Online Comment

Application H02-0673-18
Location Land off Crease Drove Crowland
Proposal Erection of 49 dwellings with associated garaging, roads and sewers

Date Submitted 04-09-18
For/Against Comments

Figure 2 – Proposed Joyce Site Layout

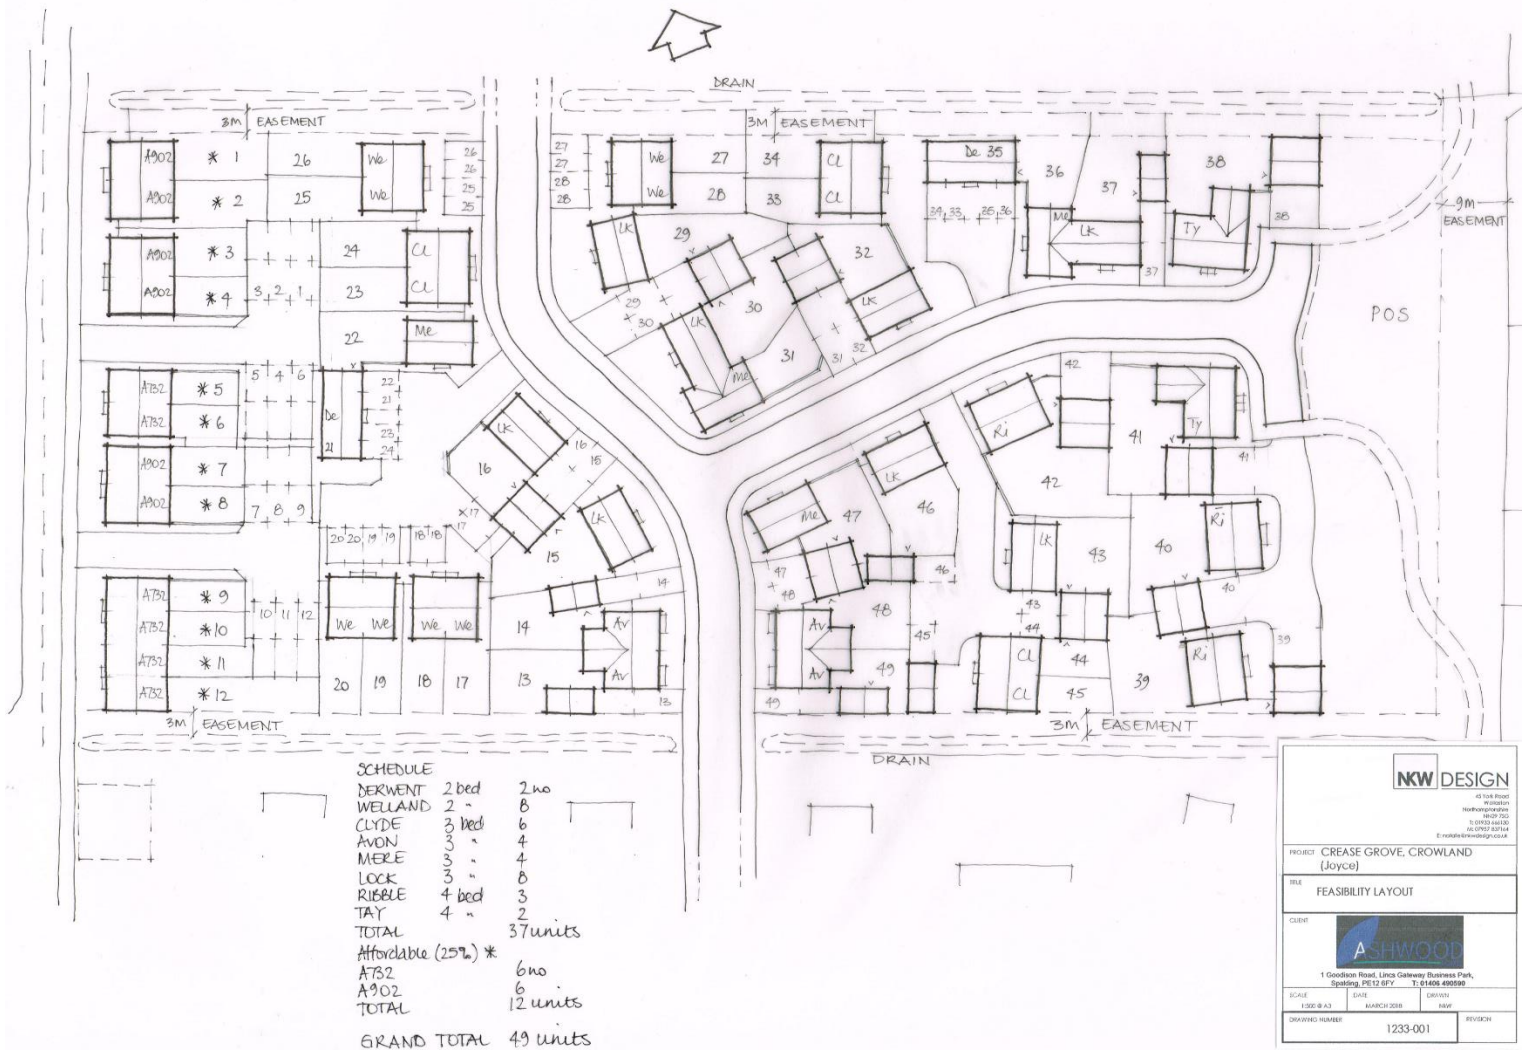
I would ask that consideration be given to the orientation of habitable rooms in the proposed properties along the Crease Drove edge of the site and would suggest that they are designed to face into the site.
